## **OXFORDSHIRE COUNTY COUNCIL'S RESPONSE TO CONSULTATION ON THE FOLLOWING DEVELOPMENT PROPOSAL**

**Application no:** 22/01682/F

**Proposal:** Development of a ground mounted solar farm incorporating the installation of solar PV panels, associated infrastructure and access, as well as landscape planting and designated ecological enhancement areas.

**Location:** Land North Of Manor Farm, Noke

Visibility Splays at Proposed Site Access

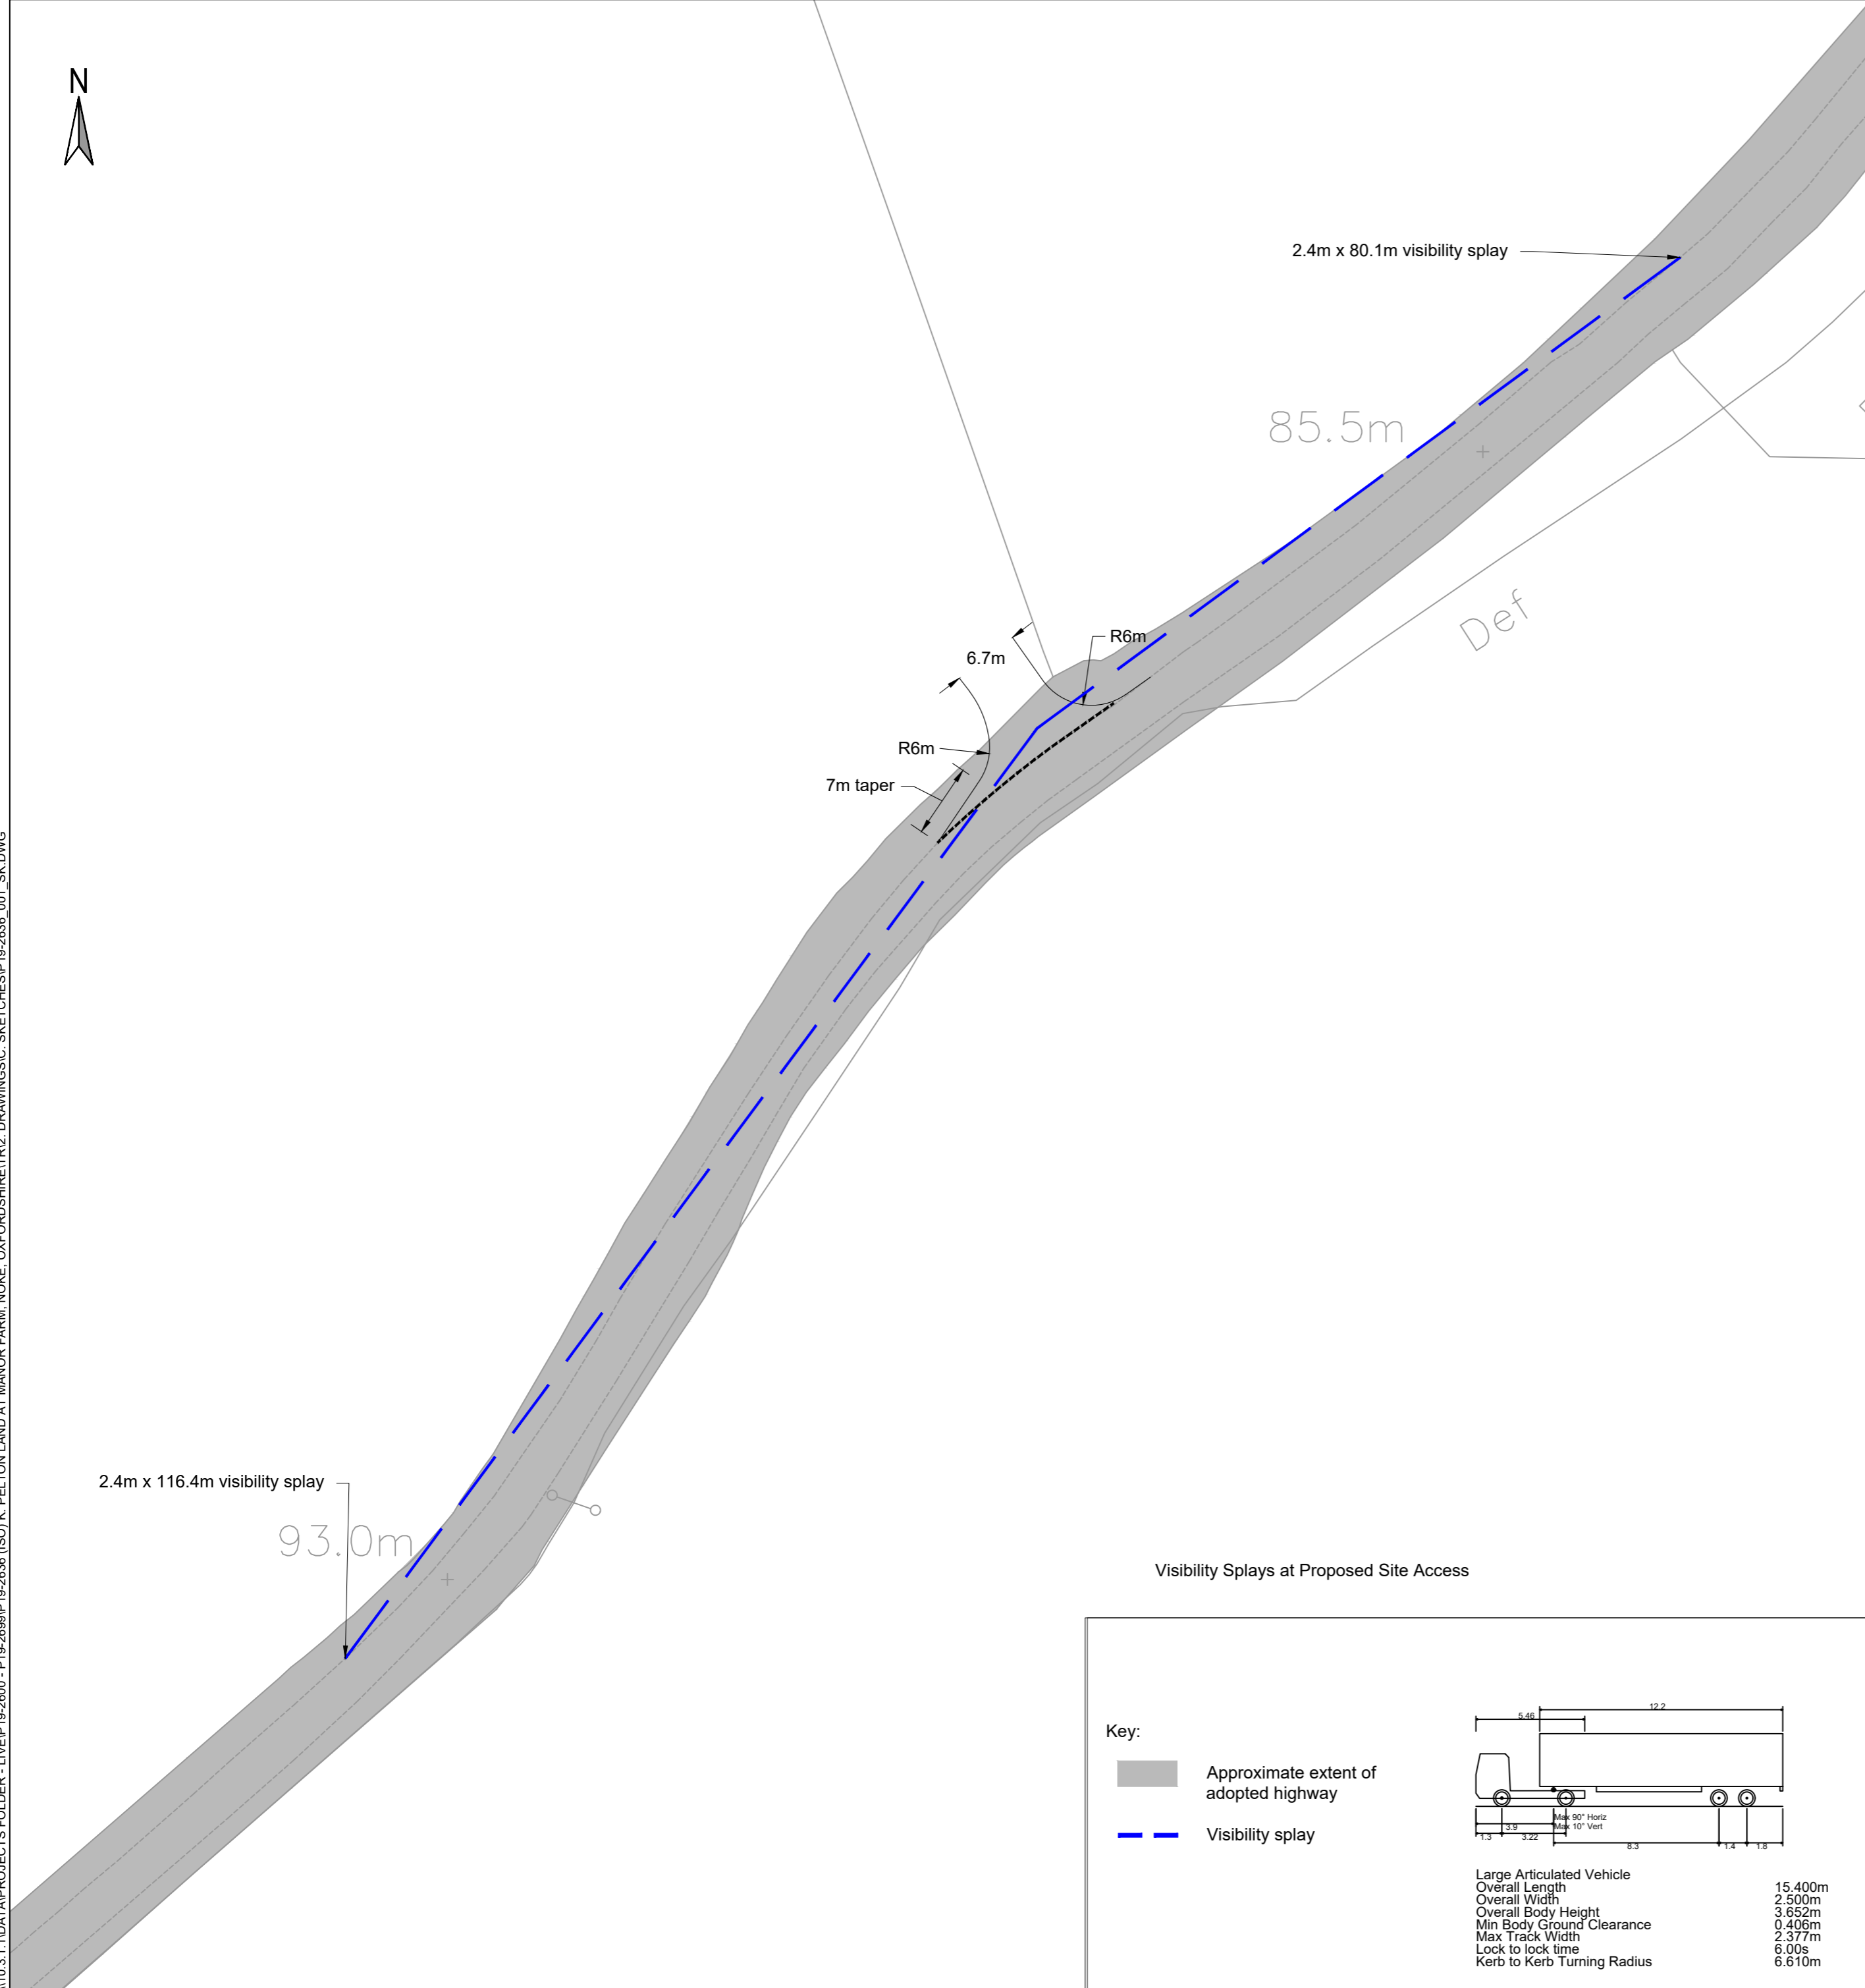
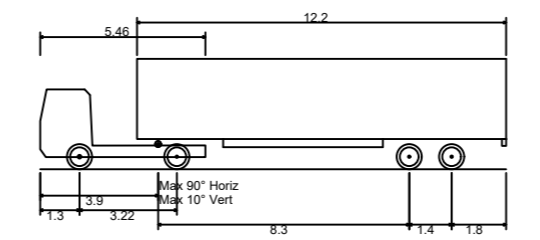
- It has not been demonstrated that the visibility splays available from the proposed site access are adequate for vehicle speeds along Noke Village Road

The new documents in this updated application do not deal specifically with the Highways reason for objection. I see that two of the emails submitted make reference to OCC Highways comments and state that a speed survey will be/has been carried out. However, an updated Transport Statement has not been included and so I am unable to give any further comment or change my recommendation.
